# Response from Newark and Sherwood District Council as Planning Authority

A46 Newark Bypass

Inspectorate's reference number TR010065

DRAWING TITLE
 FIGURE 2.3 ENVIRONMENTAL MASTERPLAN SHEET 3 OF 7

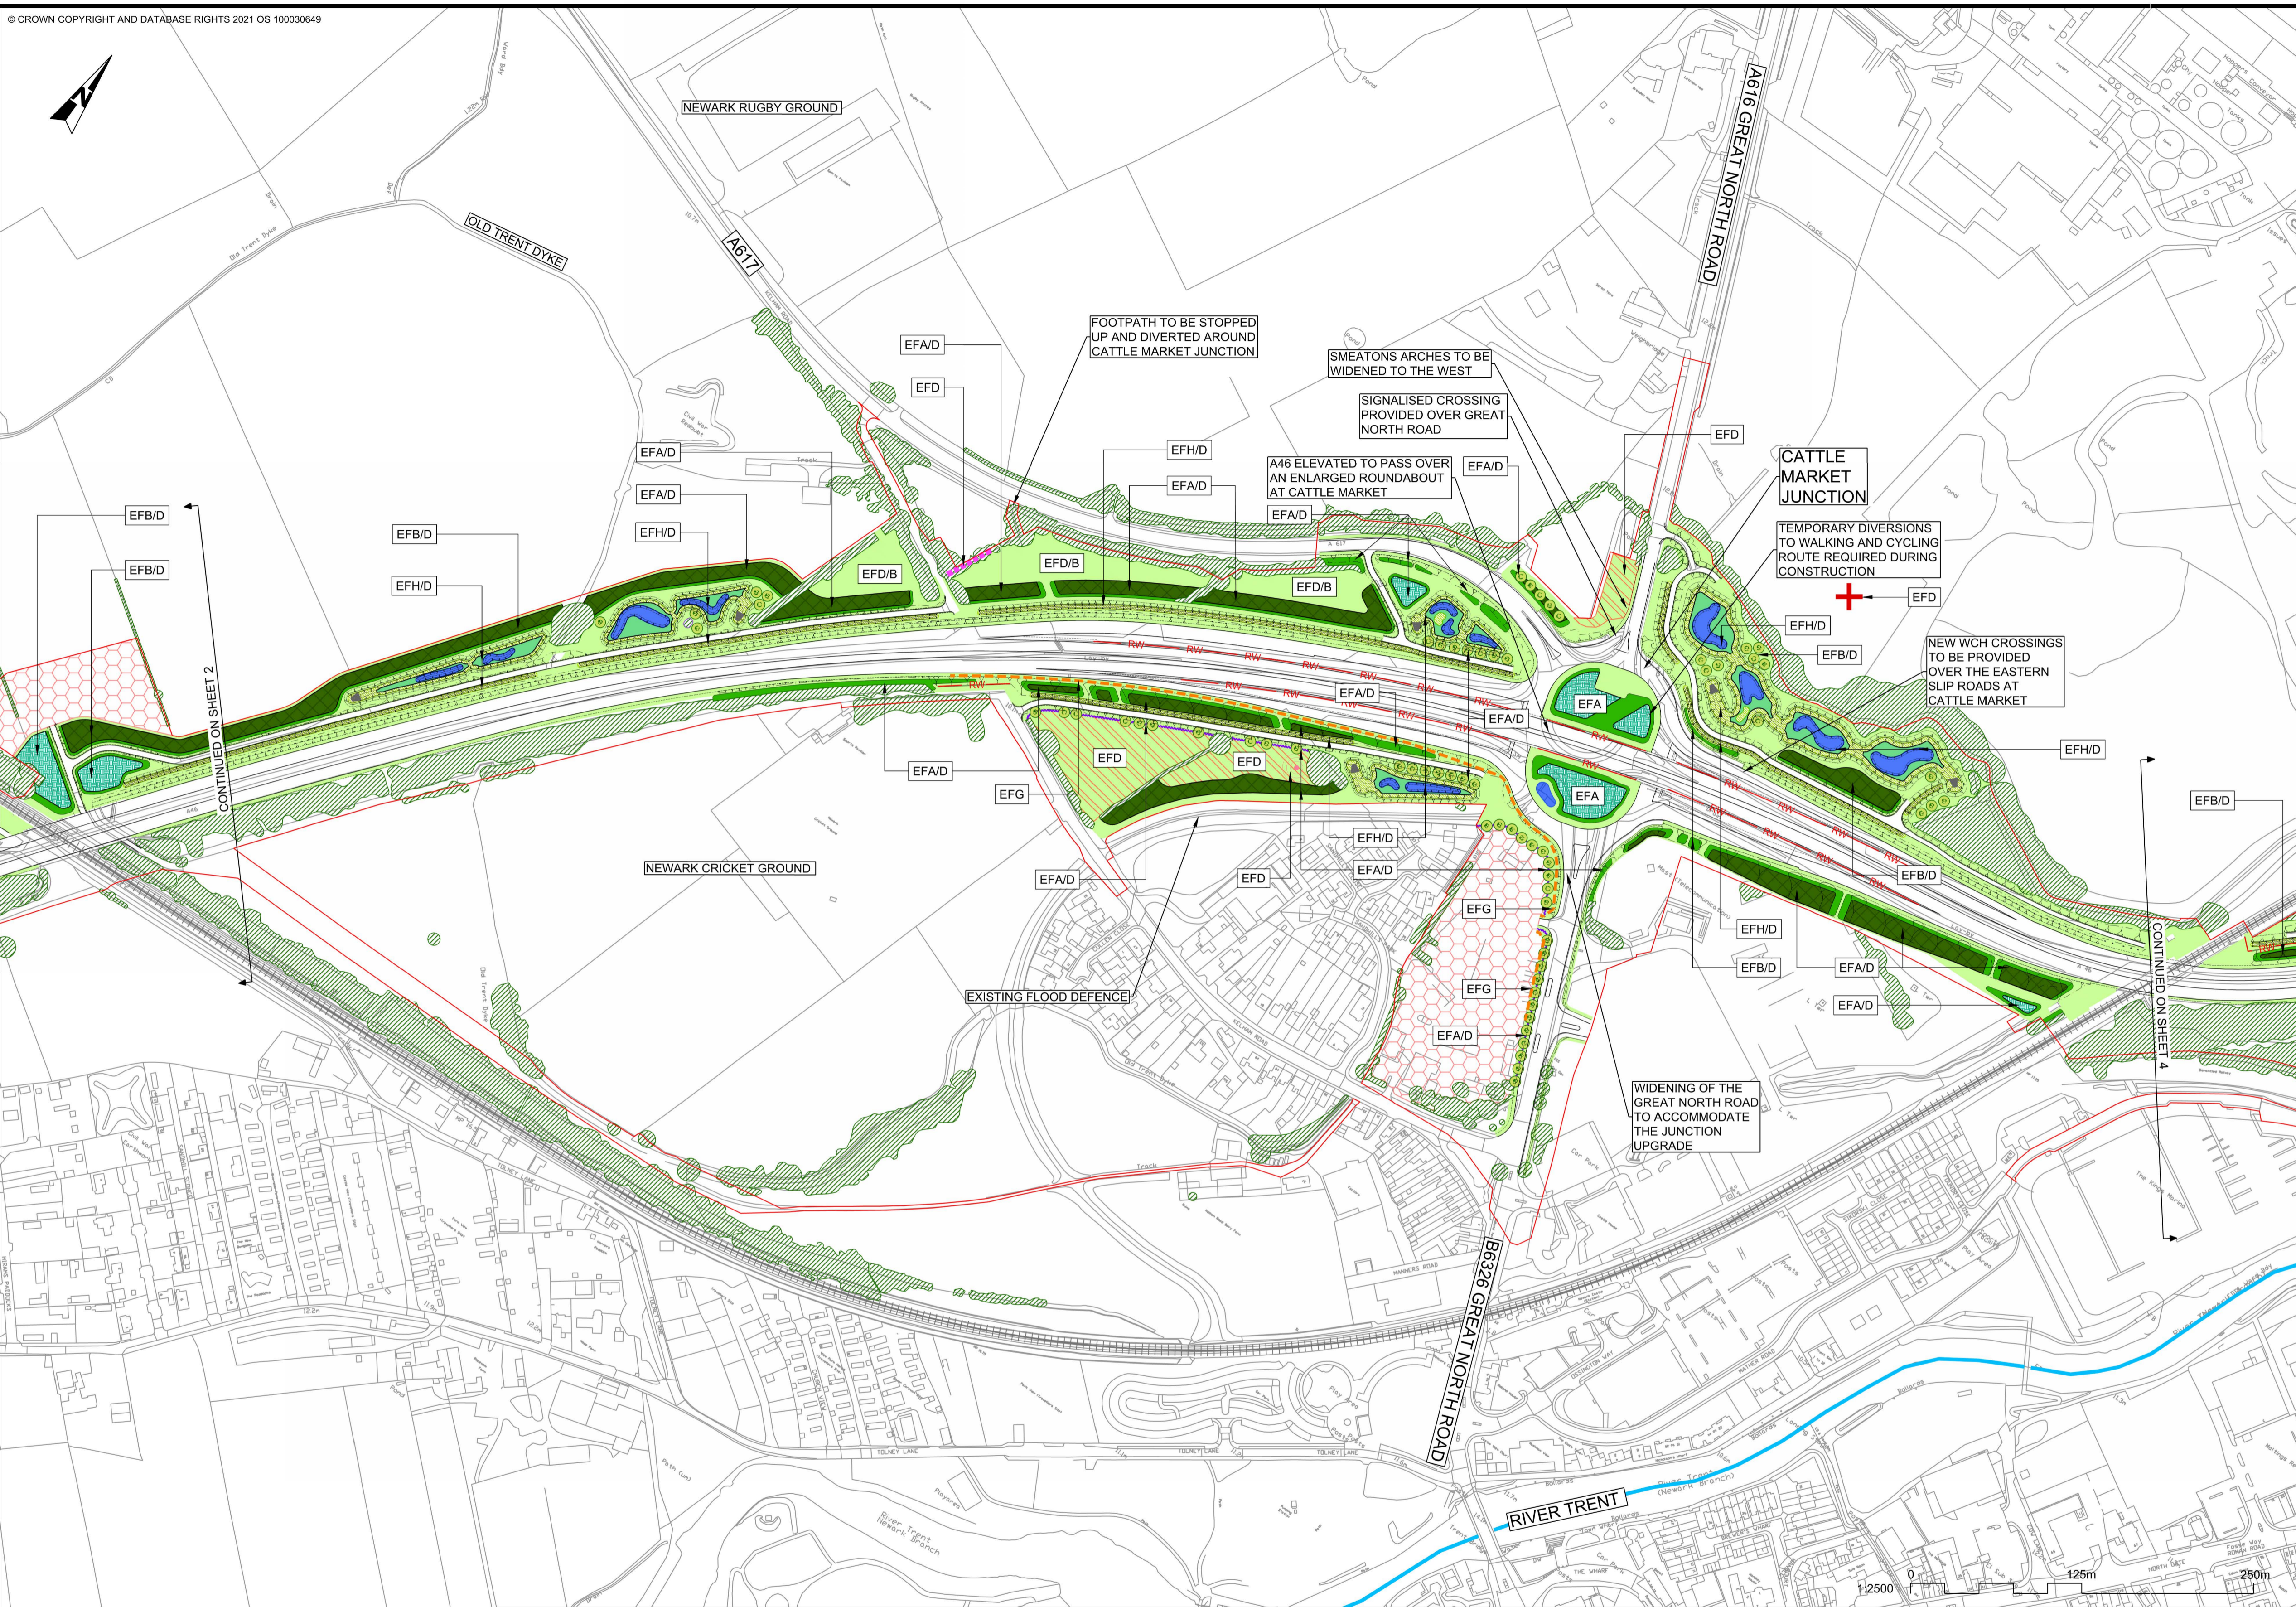
A portion of the site is highlighted blue on the submitted Land Plans Regulation 5 (2) (i) Sheet 3 of 7. The blue shading denotes 'land to be used temporarily and rights to be permanently acquired'.

**Viewpoint 24: View north from Sandhills Park representative of views for residents.**

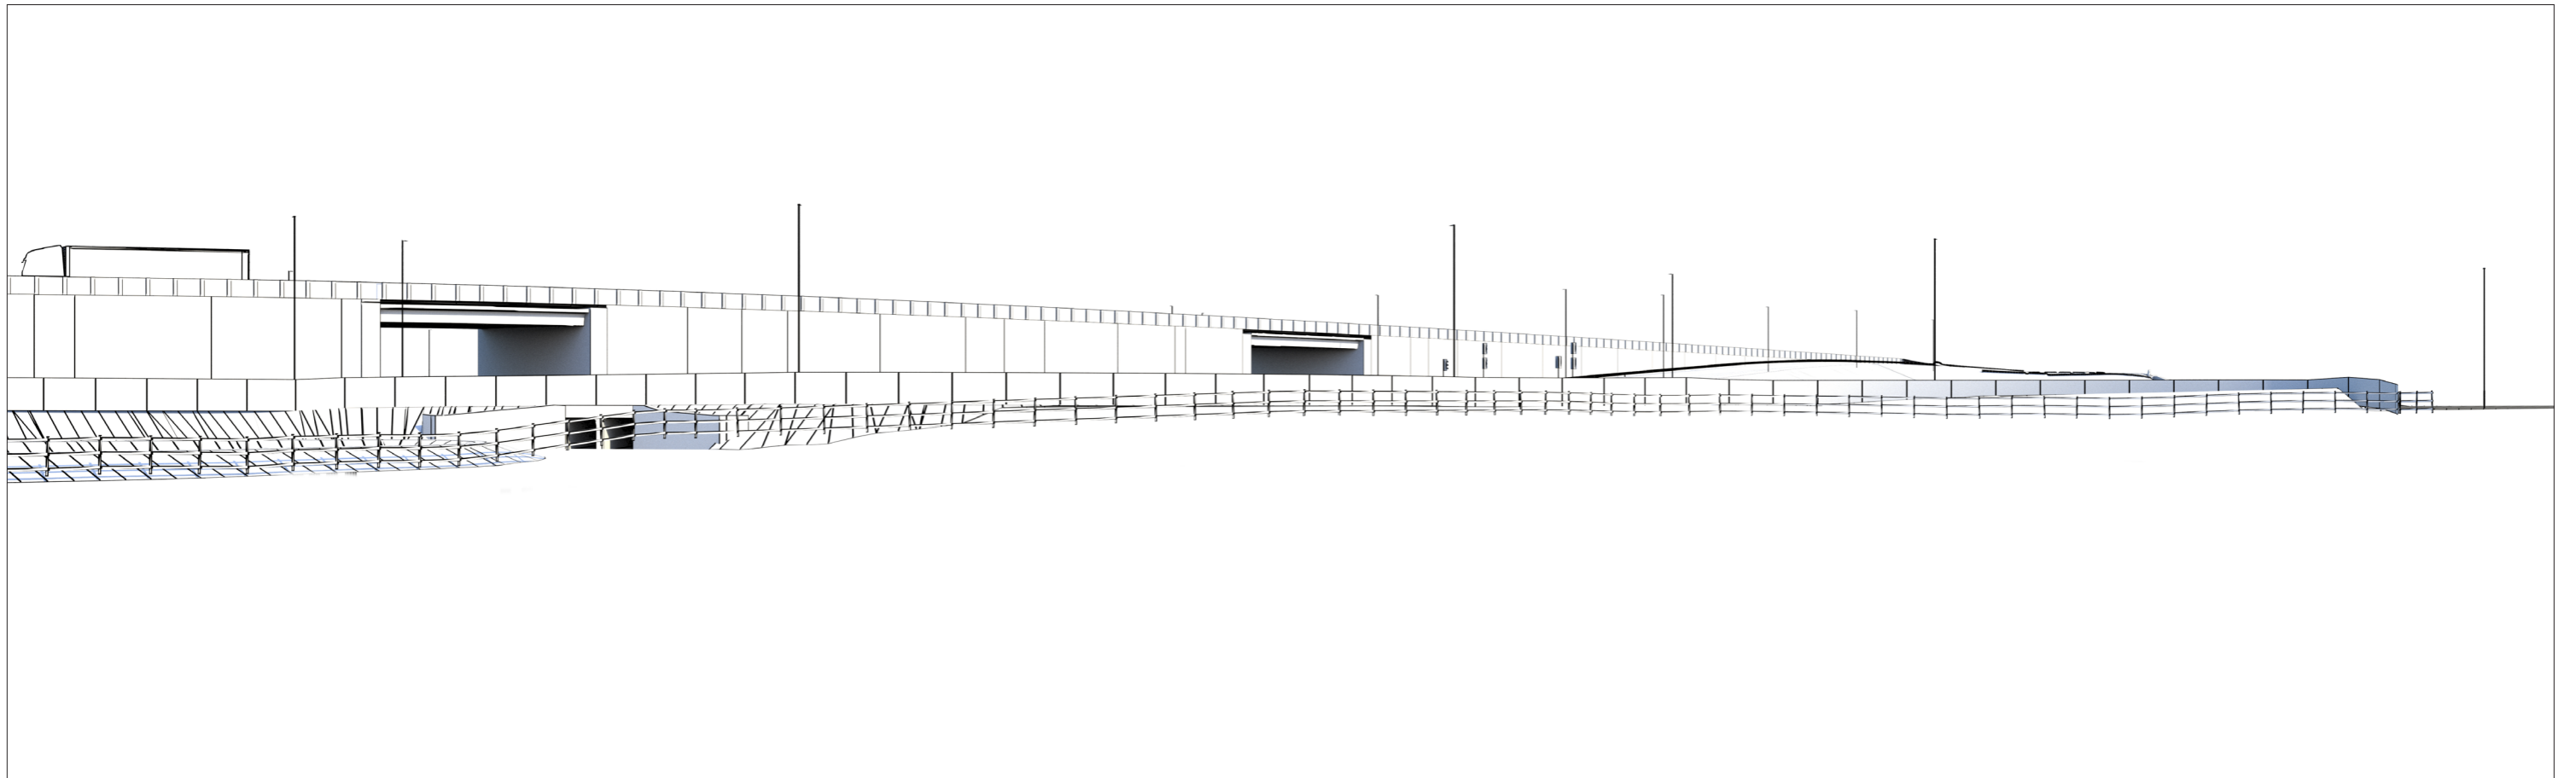
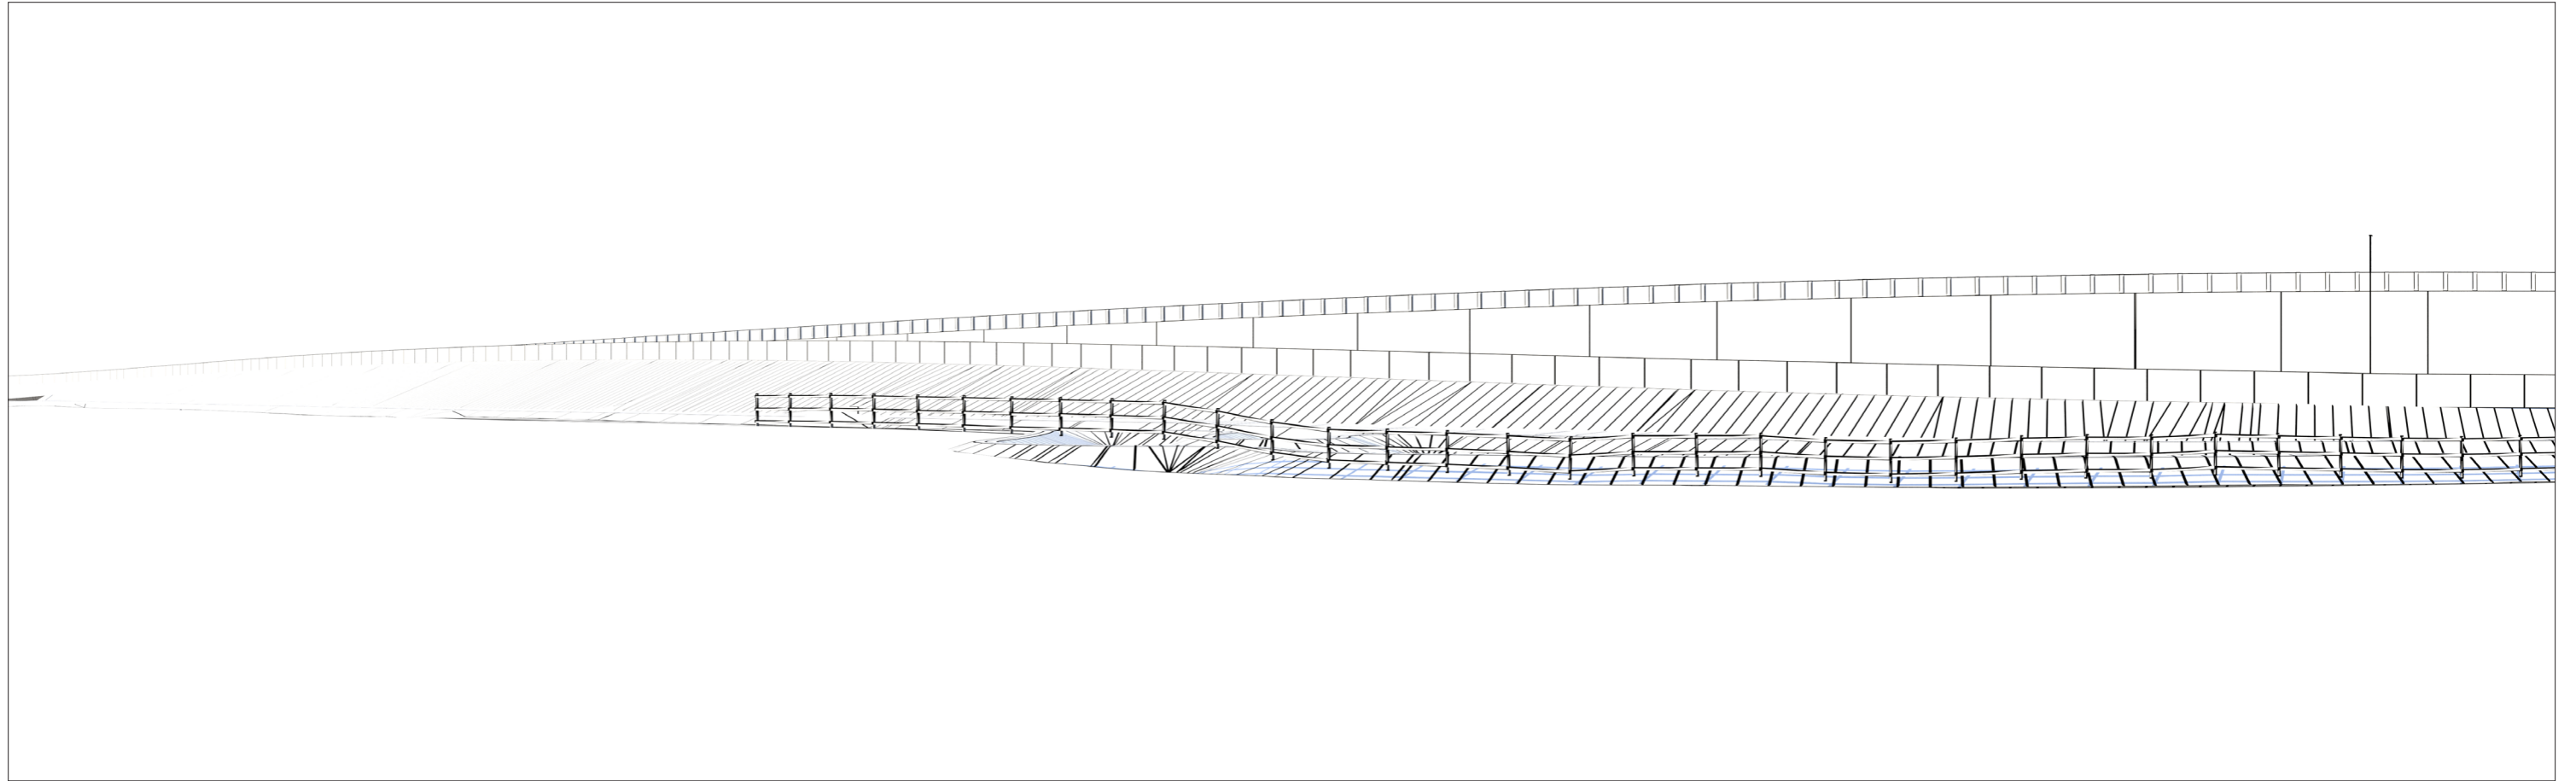
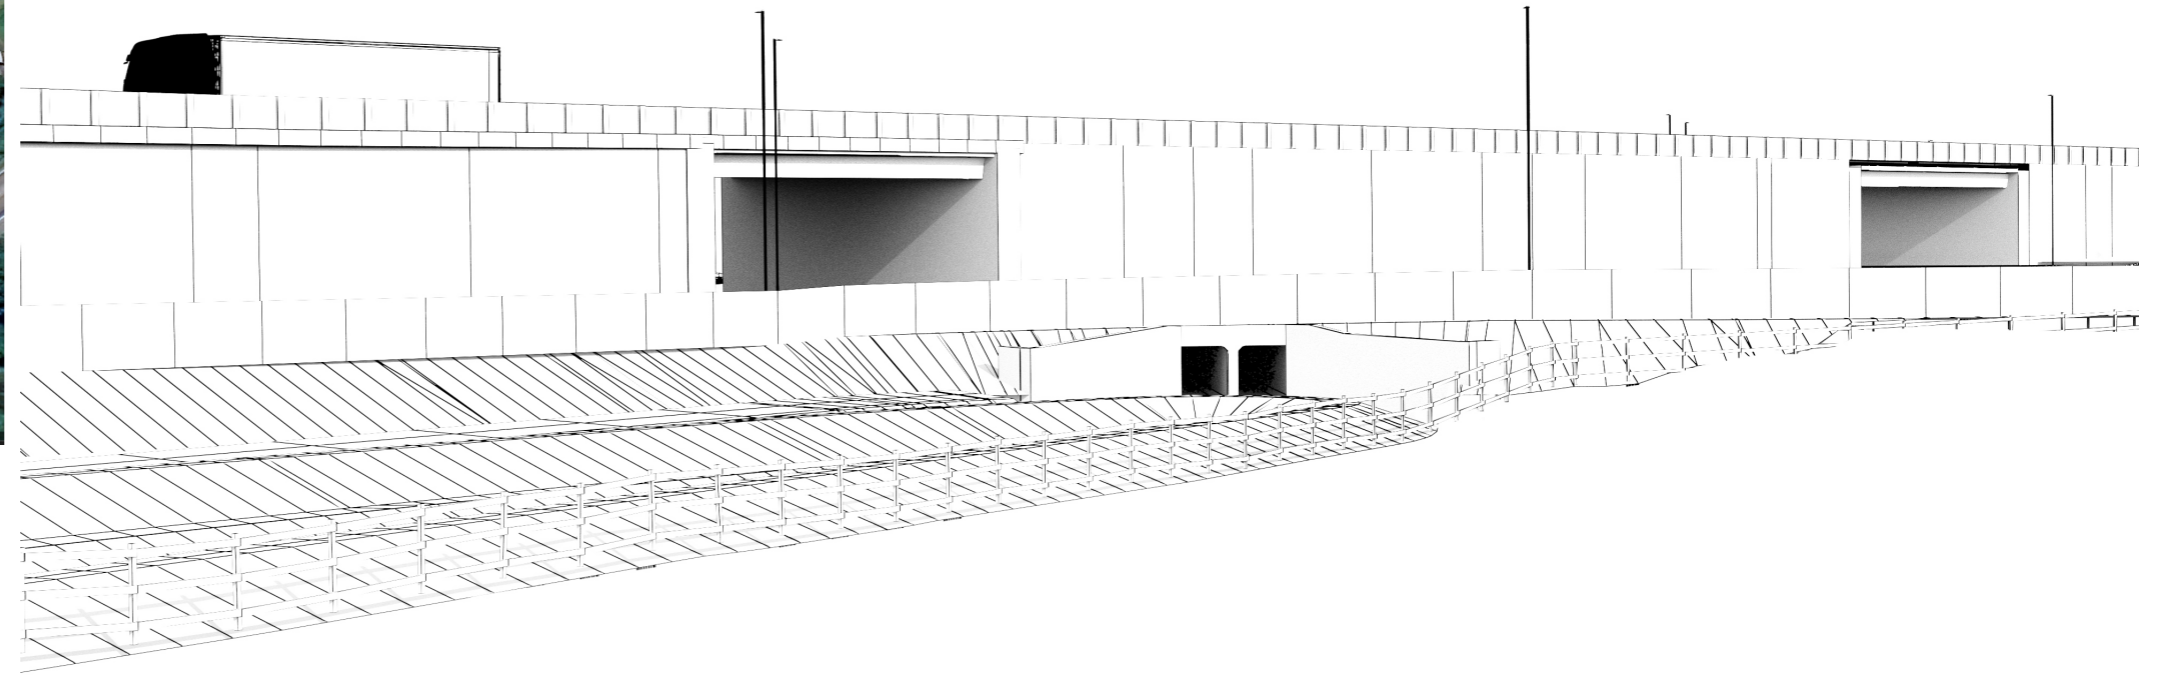
- Effects on residential amenity – The Council considers that insufficient mitigation has been put forward to mitigate for the existing residents in the area of Cattle Market roundabout and especially those visual effects to residents of Sandhills Park and Close;
- Traffic and transport;
- Flood risk and drainage;
- Impact on the loss of trees;
